Development Control
Ribbles Valley Borough Council

App no: 24.0996

Address: 98 Ribchester Road and land adj 94 Ribchester Road Clayton-Le-Dale

Proposal: Approval of details reserved by conditions 4 (Construction Management Plan), 5 (site access and off-site works), 9 (SW drainage), 12 (drainage scheme) and 14 (landscaping) of planning application 3/2024/0302.

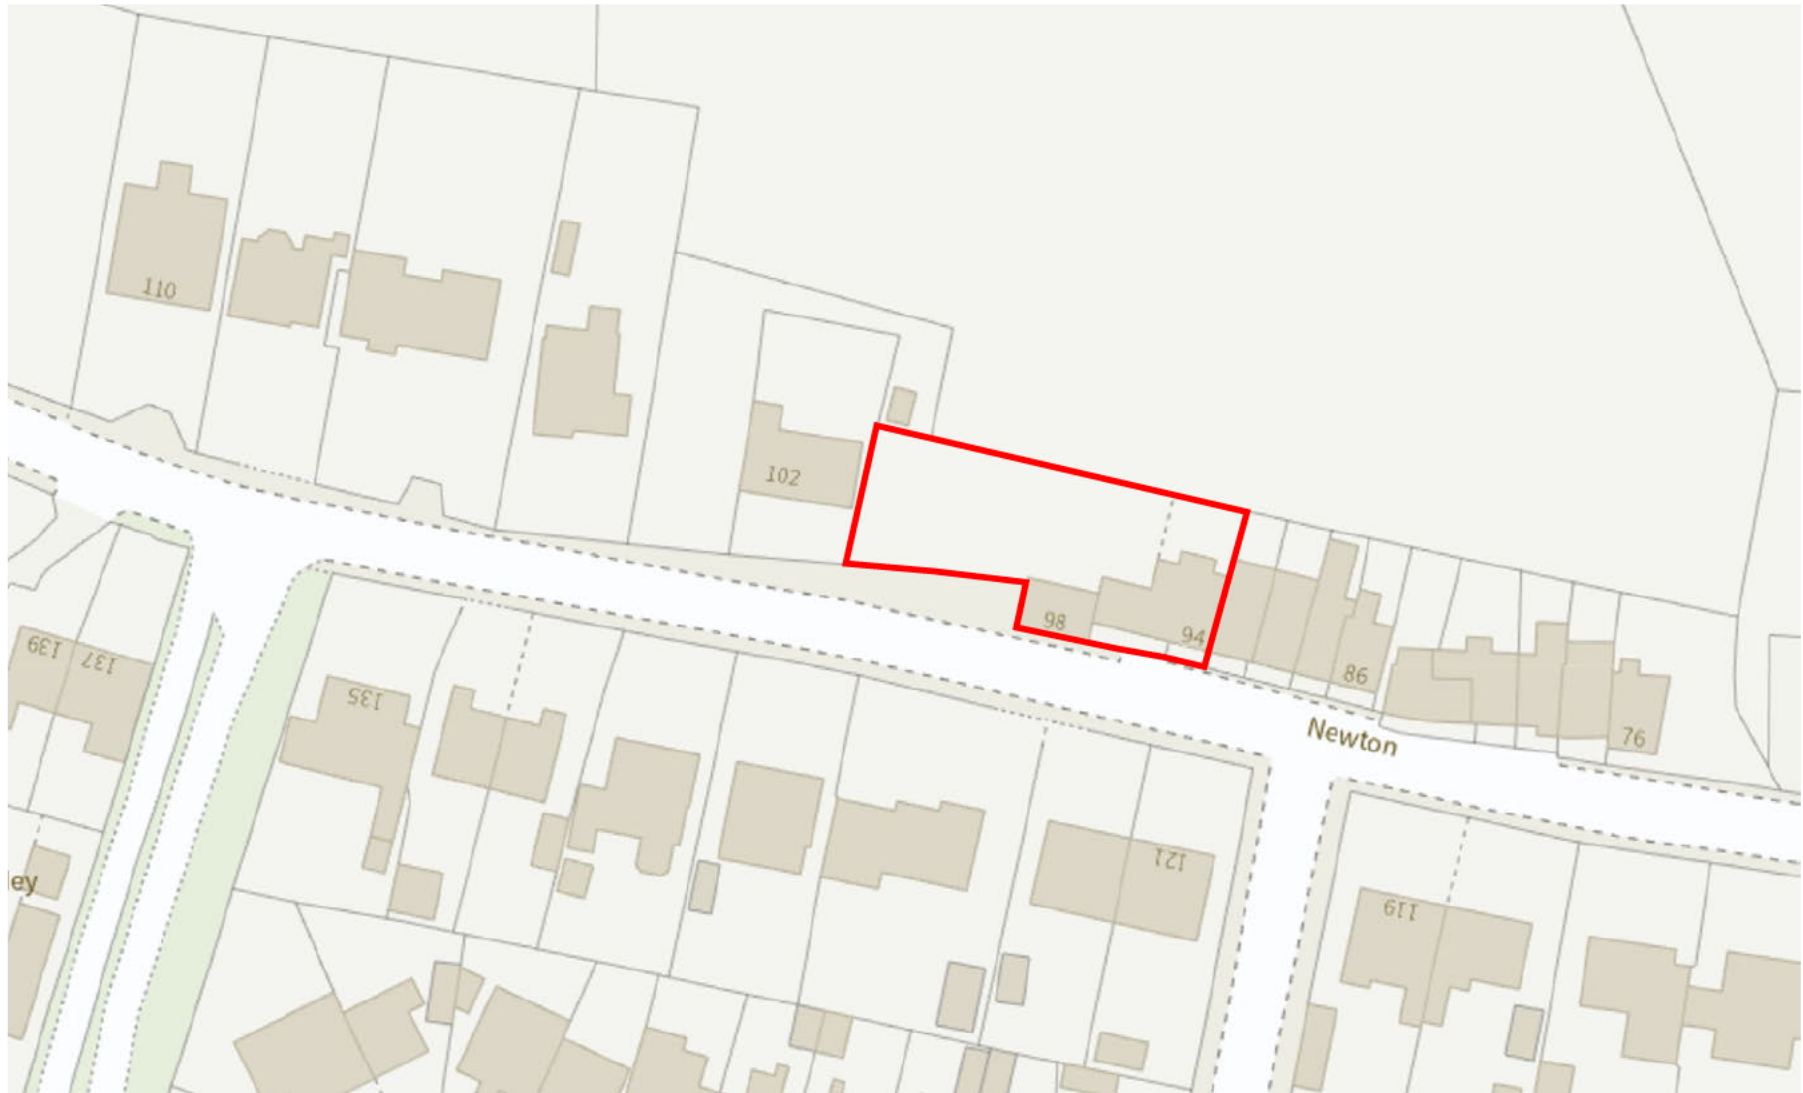
Condition 9 - The surface water from the approved access, parking and turning areas shall be collected within the site and drained to a suitable internal outfall within the site boundary or constructed in porous materials. The scheme shall be implemented and thereafter retained in accordance with the above details prior to occupation of the dwelling.

Ribchester Road is higher than the proposed access and driveway. Run-off of surface water from the highway to the site will be dealt with as part of the S278 process.

There is no objection to the discharge of this condition.

Section 278 Works

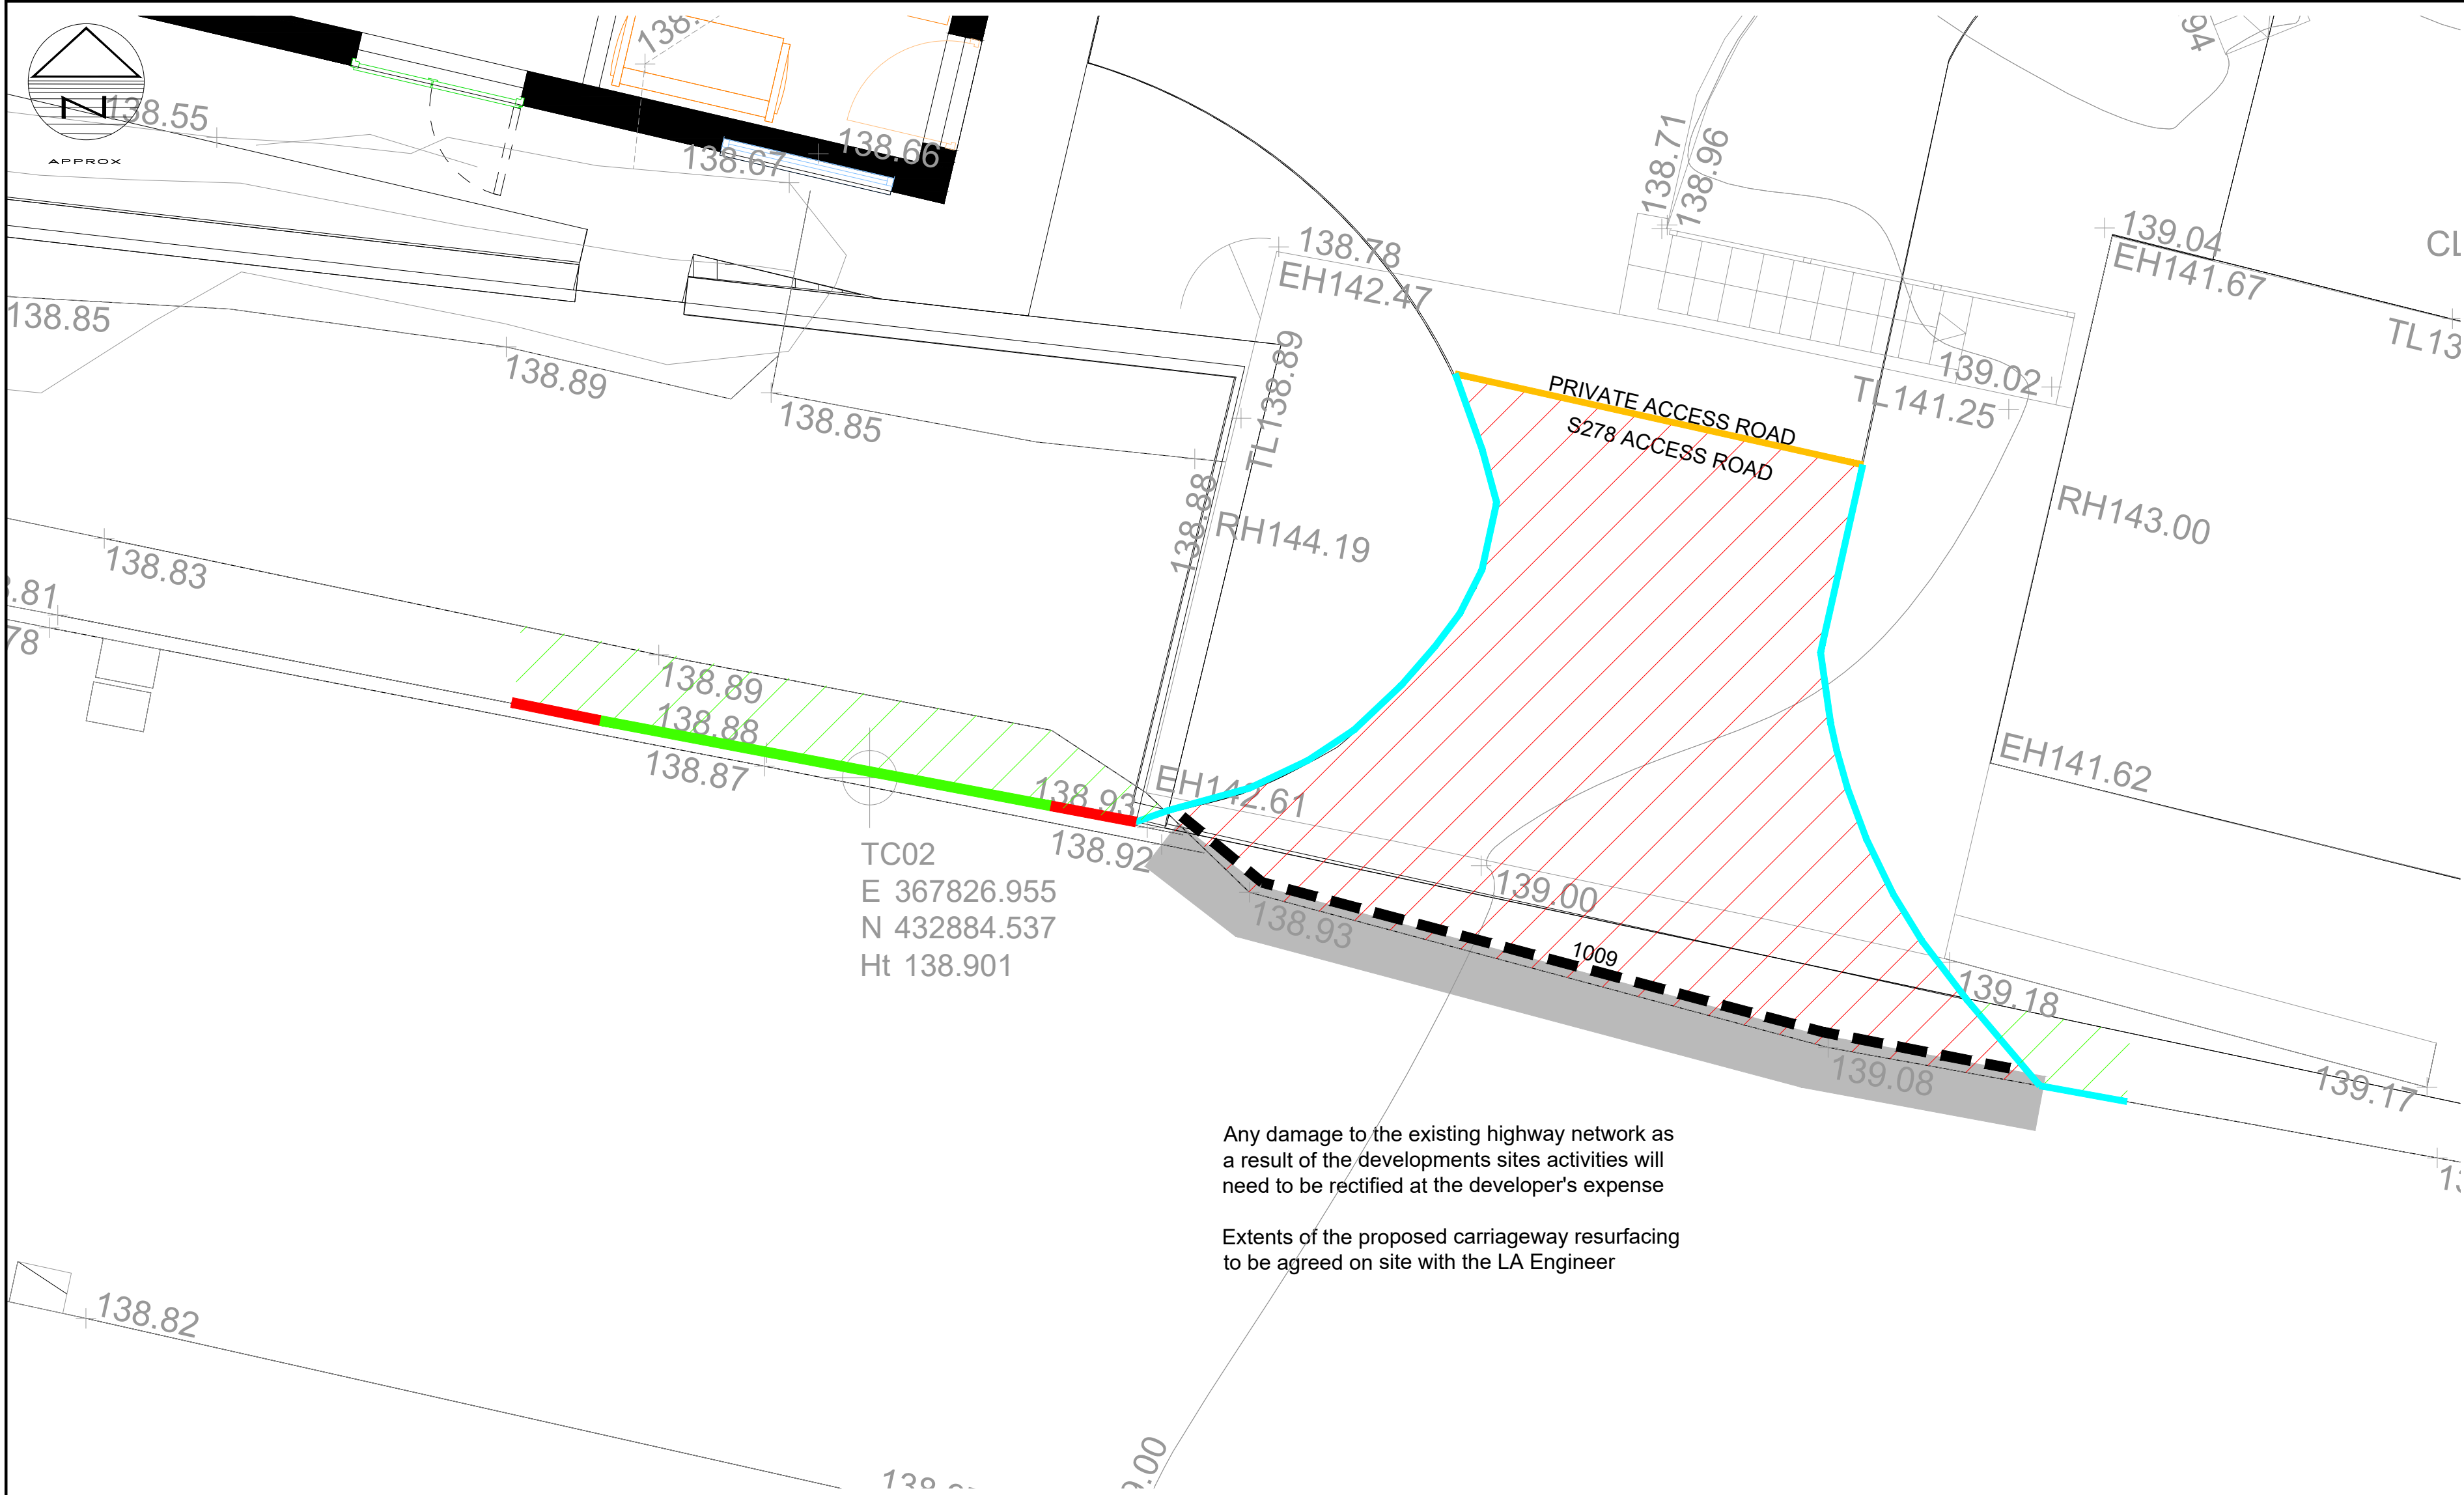
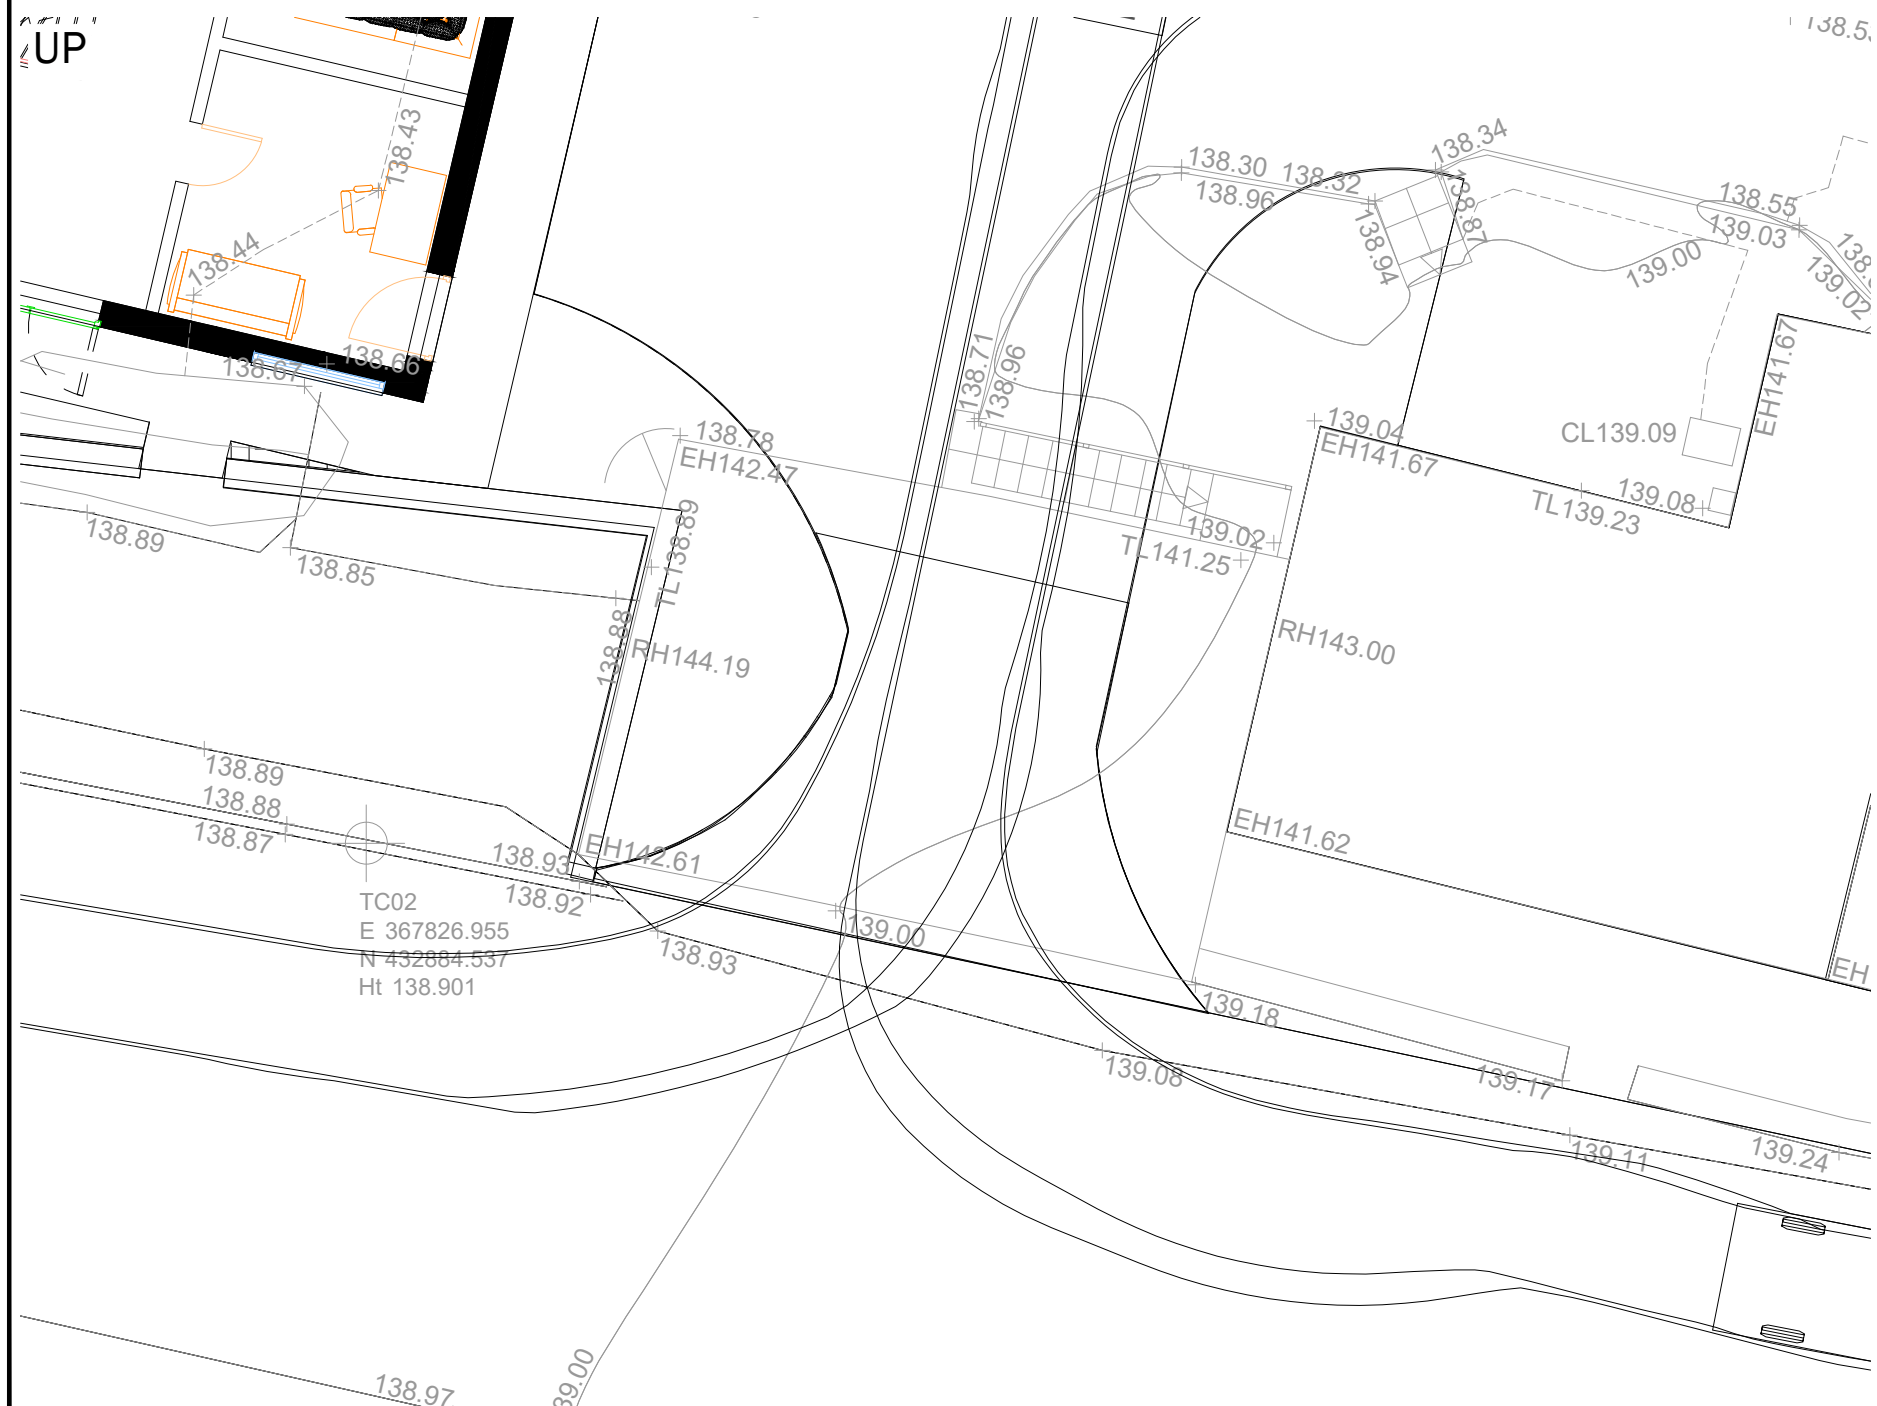
Condition 5 - No part of the development hereby approved shall commence until a scheme for the construction of the site access and the off-site works, namely a scheme which should tie into the site access and should include a kerb line/ edge restraint from the access to 94 Ribchester Road, have been submitted to and approved in writing by the Local Planning Authority. The works shall be completed prior to first occupation of the dwelling.

There is no objection to the discharge of this condition. The S278 agreement is progressing between the developer and Lancashire County Council.
